Our Ref: M/75/21/NMA

**Section 96A of the Town & Country Planning Act 1990 (as amended)
Town and Country Planning (Development Management Procedure) (England) Order 2015
(as amended) - Article 10**

Non material amendment following grant of M/83/20/PL for the front elevation upper floor windows (W1-03 & W1-04) adjusted in height and gym annexe roof reduced by 316mm; ground floor door (DG-04) has glass panel; ground floor window to gym annexe WC & house plant room removed; glazing bars design changed on some windows throughout but no size change; chimney on front & rear elevations 15cm wider, on side elevations chimney is 15cm narrower, height remains the same; all timber & slate vertical cladding replaced by stone cladding and garden wall - cut back, curved section removed
18 Old Point Middleton-On-Sea PO22 7RY

PROPOSED EAST AND
WEST ELEVATIONS & SITE
SECTION

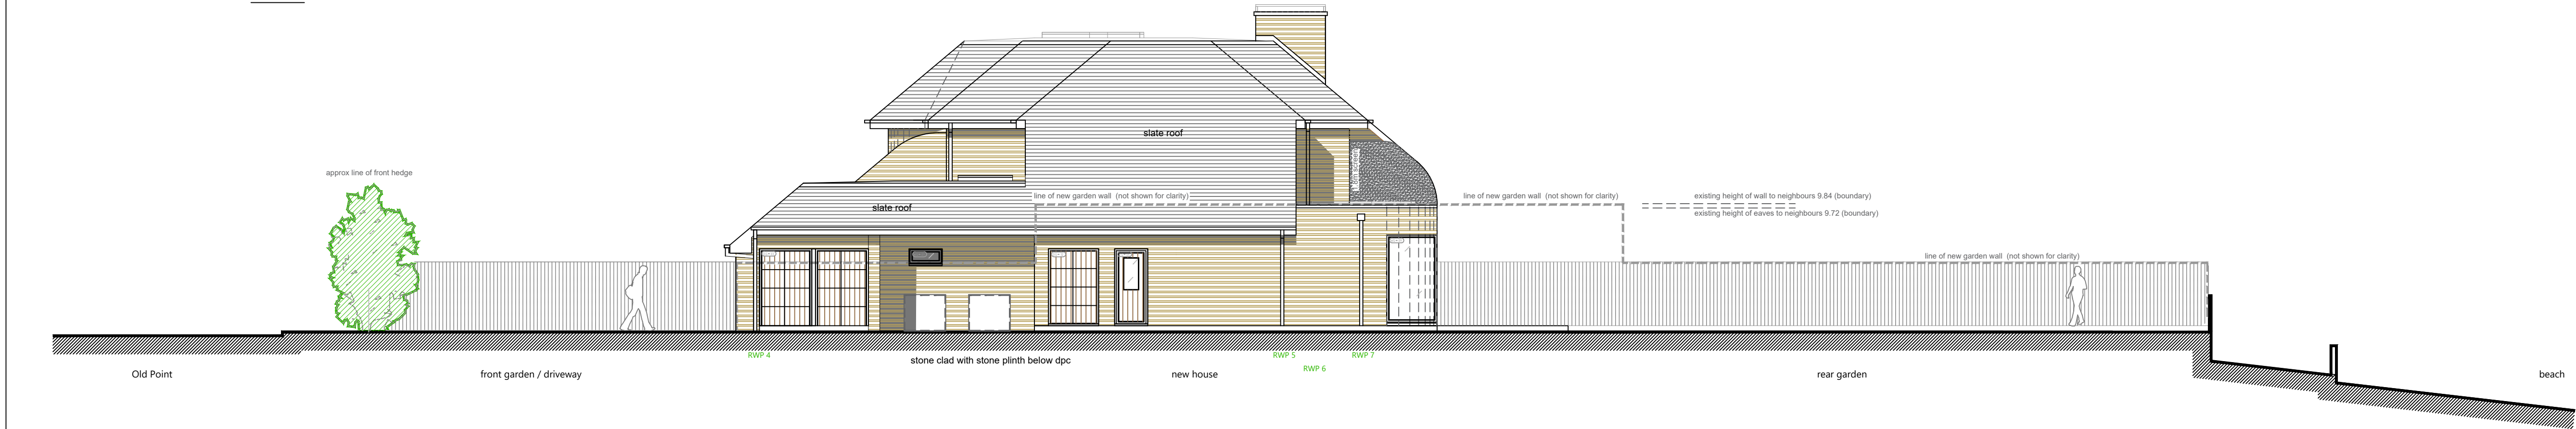
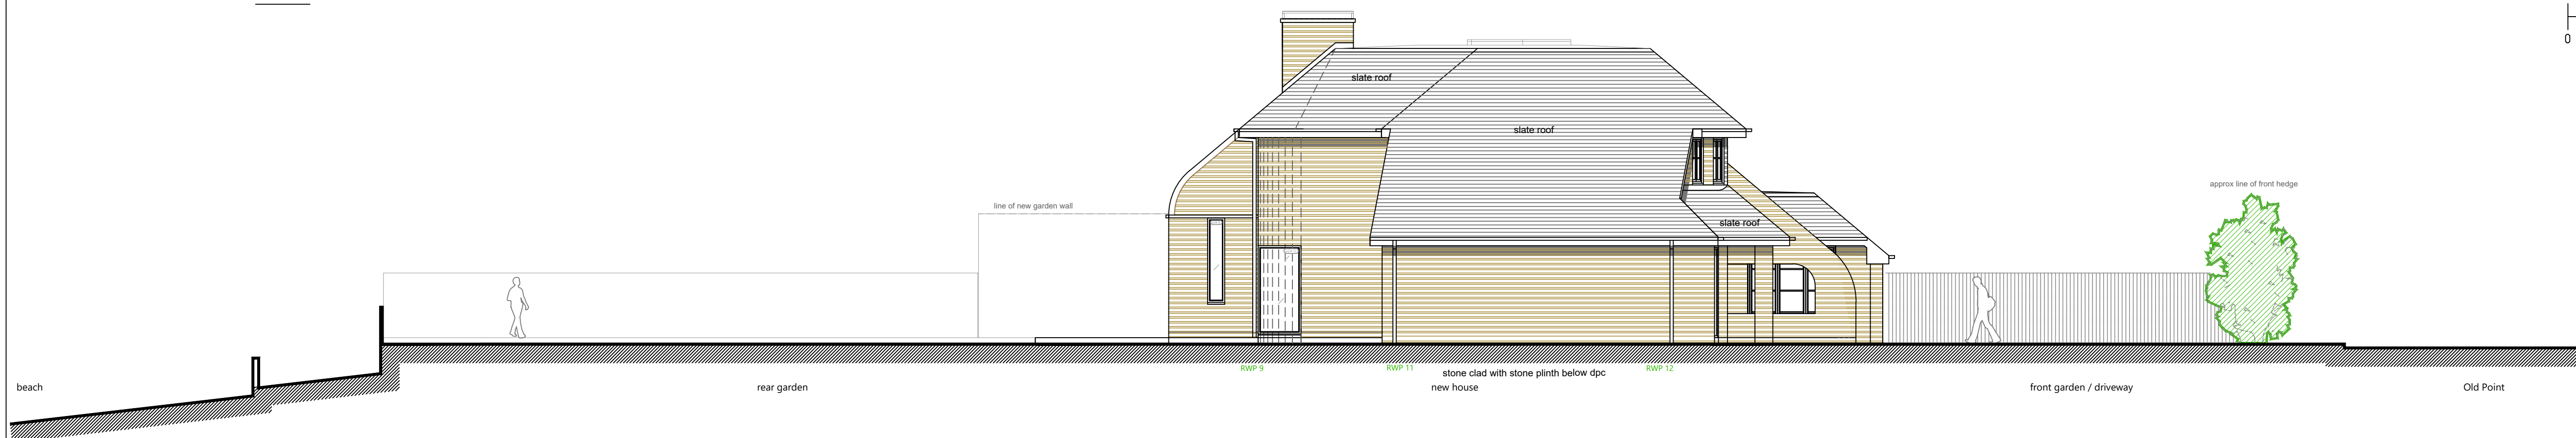
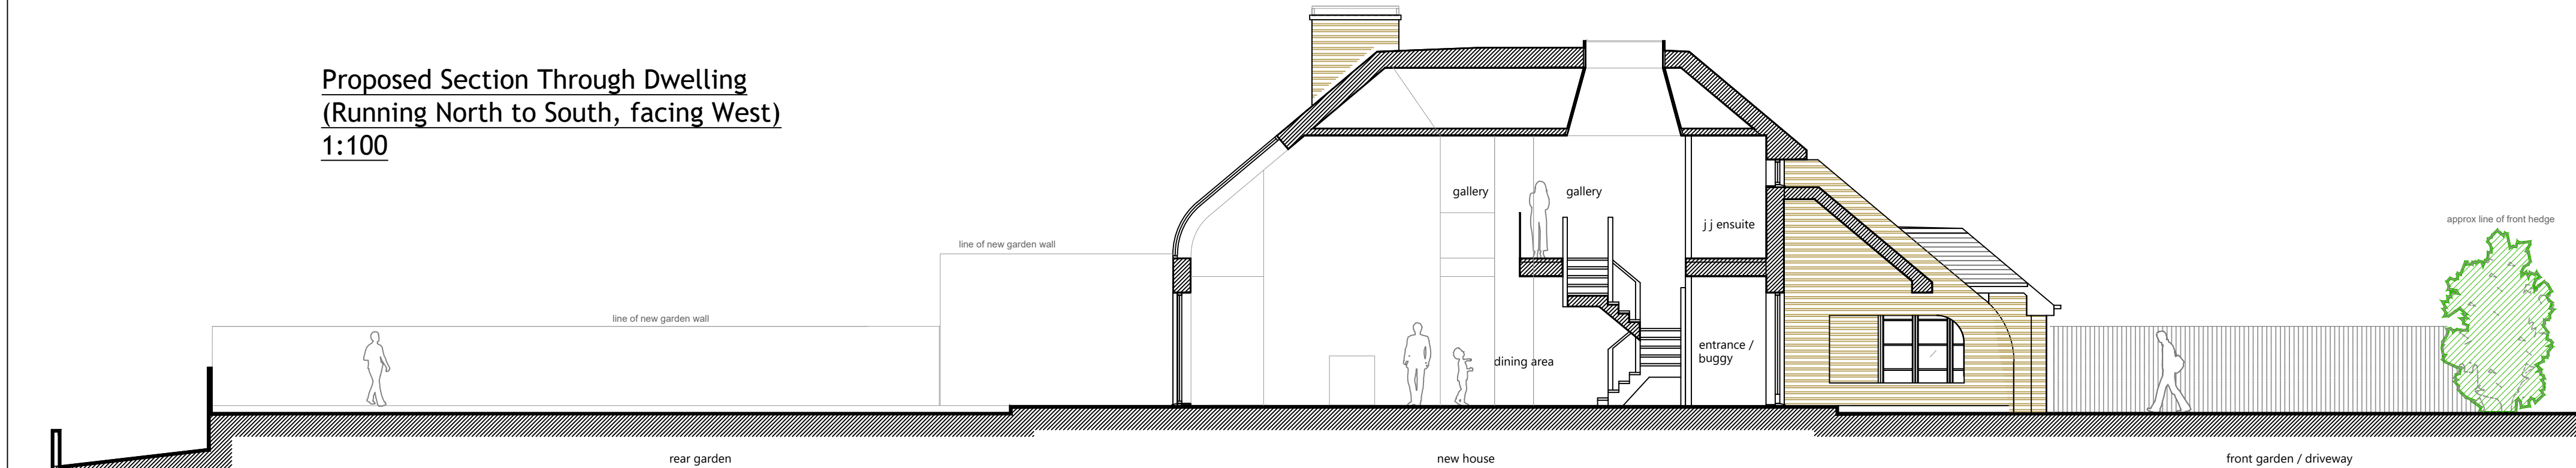
Non material amendment following grant of M/83/20/PL for the front elevation upper floor windows (W1-03 & W1-04) adjusted in height and gym annexe roof reduced by 316mm; ground floor door (DG-04) has glass panel; ground floor window to gym annexe WC & house plant room removed; glazing bars design changed on some windows throughout but no size change; chimney on front & rear elevations 15cm wider, on side elevations chimney is 15cm narrower, height remains the same; all timber & slate vertical cladding replaced by stone cladding and garden wall - cut back, curved section removed

It is considered that the proposed changes will not materially alter the appearance of the

development approved by the planning permission, do not conflict with any conditions of the permission, do not breach any planning policy, do not warrant re-consultation and are within the maximum dimension change tolerances.

The changes can therefore be considered as an NMA under section 96A of the Town and Country Planning Act 1990.

Proposed East and West Elevations: Drawing No: 302 REV F
